SNEATH'S MILL
TRUST

5th December 2016

Further to our conversation last Friday, I would like you to raise the following points with Mr Phillip Congreave.

OUTLINE PLANNING DRAWING

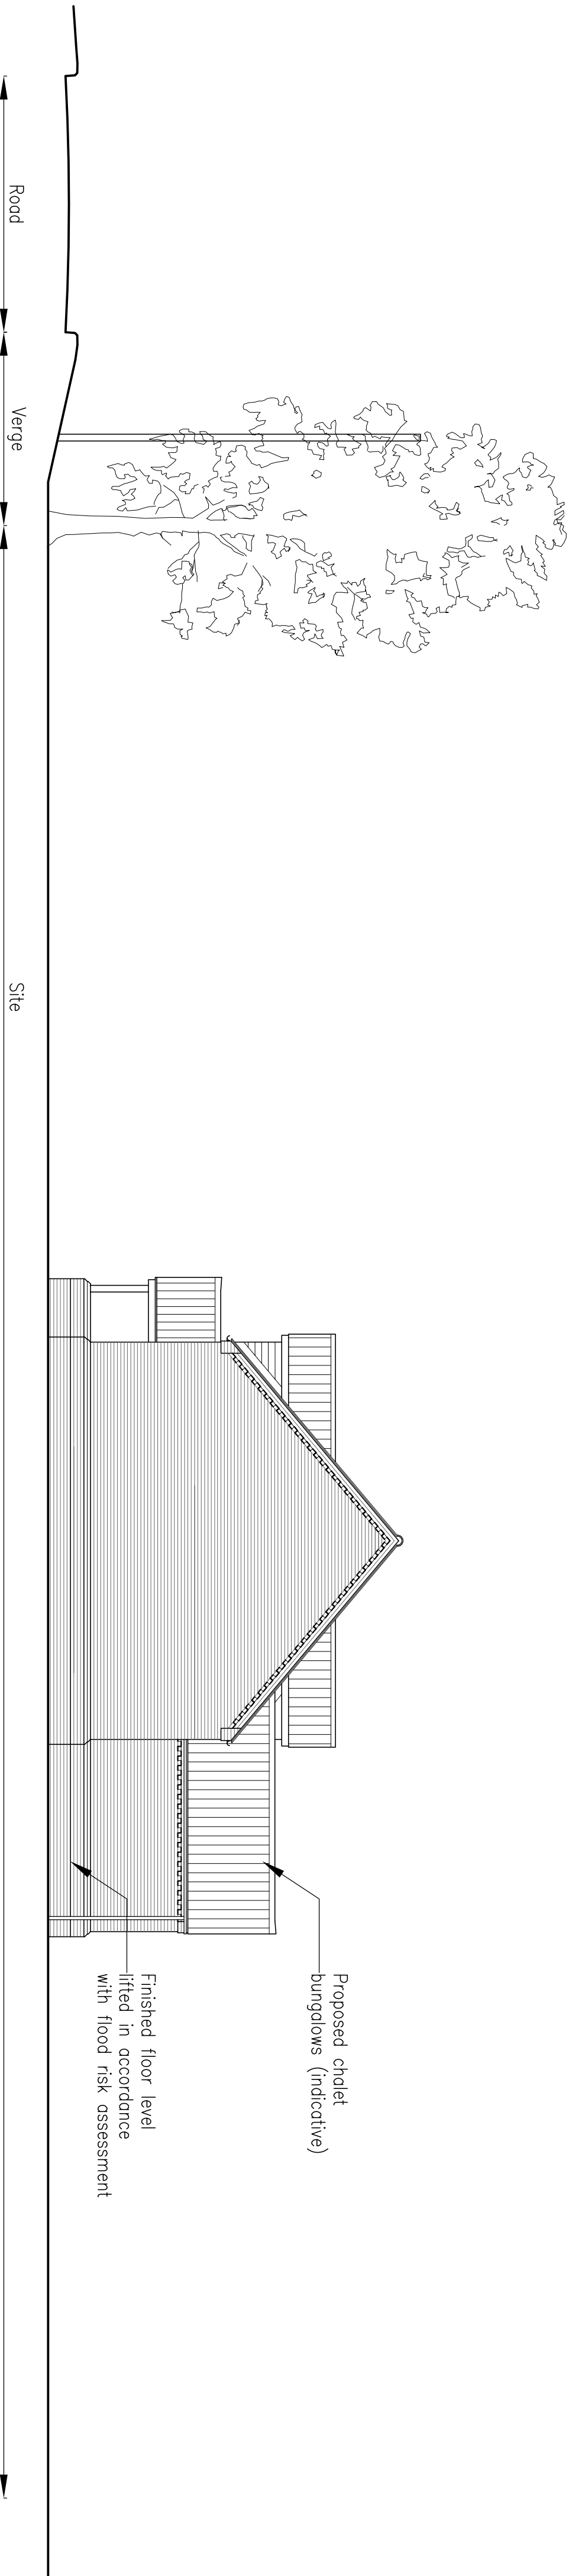
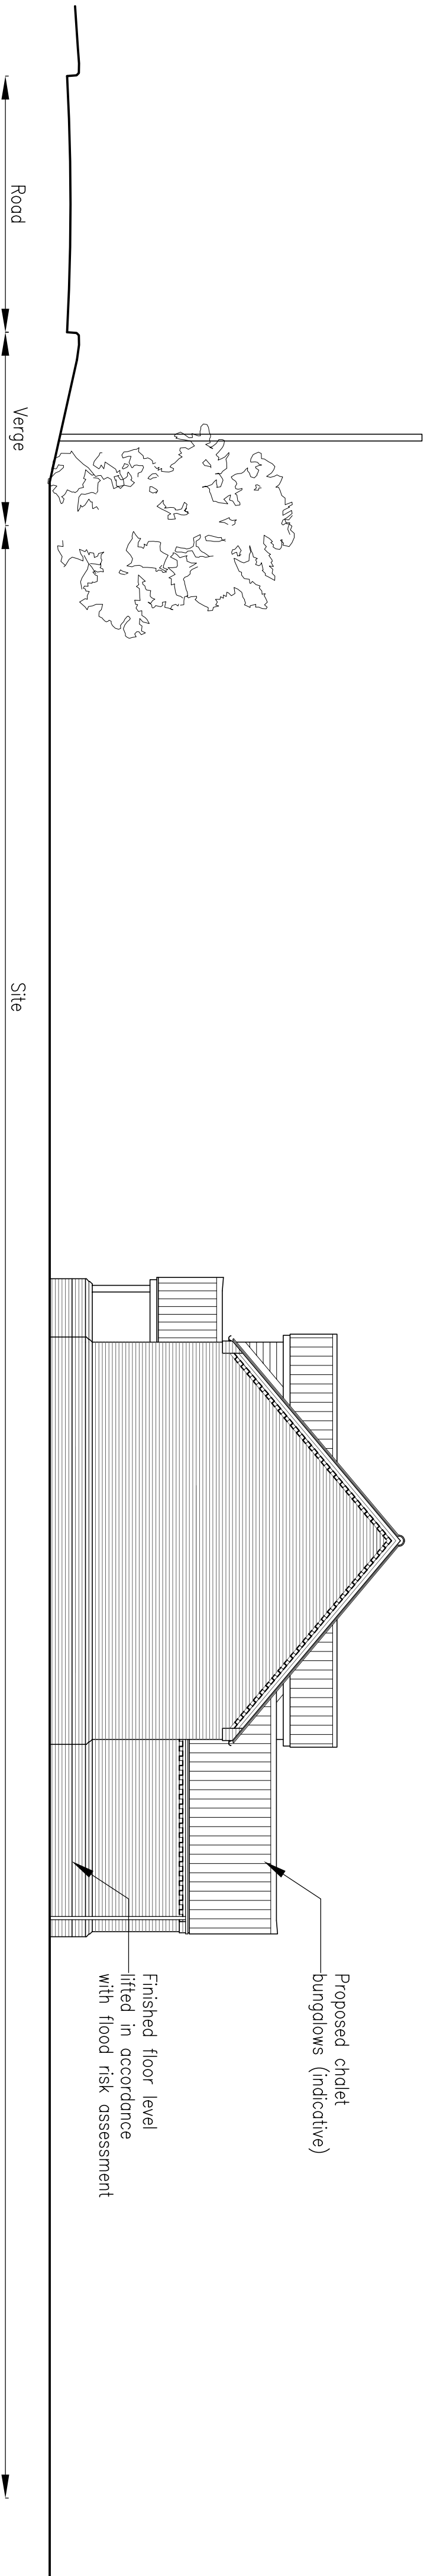
1. We are concerned about the water being shed from the site onto the road.
2. We would like to see more mature trees planted in the hedge.
3. We would prefer to see Chalet type bungalows on the site rather than houses.
4. We are concerned that once these homes are occupied, there will be complaints against the established business opposite the site, and ask if anything could be written in the contract to stop this happening.
